# OBJECTION TO PLANS TO MODIFY AND EXTEND THE PARK HYATT HOTEL

Park Hyatt: MP09\_0044

10a_37 Fort Street Level 1 Window

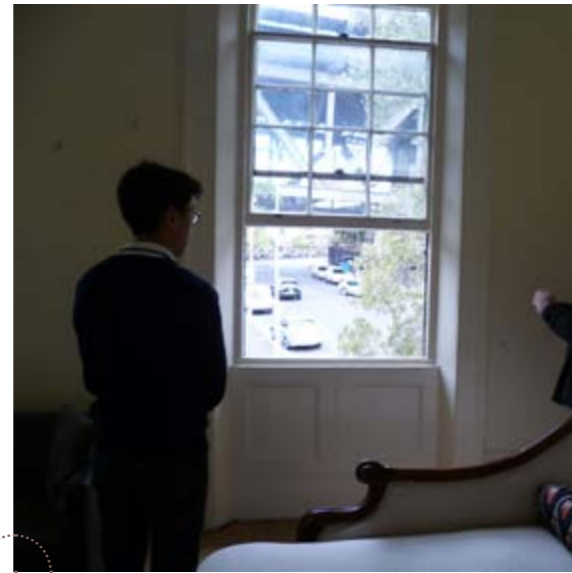
We object that this historic panorama will be heavily impacted by the proposed development. Right across the centre of this panorama will be new Park Hyatt structures. After construction, our current panorama of Sydney Harbour will be reduced to a few slot views, and the existing sense of our panoramic view across the harbour will be lost.

In their submission, Park Hyatt claims the loss of panorama of the harbour that can be seen from number 37 will be compensated by additional view of sky. If there is to be additional view of sky, it must

be a miniscule amount, and we would be pleased for Park Hyatt to indicate the location and extent of this improvement in the above photograph.

Additionally, when photos were to be taken by the proponents of this plan, we asked that any photos of the outlook from the houses and park along Lower Fort Street be taken not in the afternoon when it is more difficult to see through the trees. This was when the photos were taken. We are happy to look through trees to this outlook, and object to Park Hyatt seeking to justify plans to take these views from us on the basis that there are trees in the park.
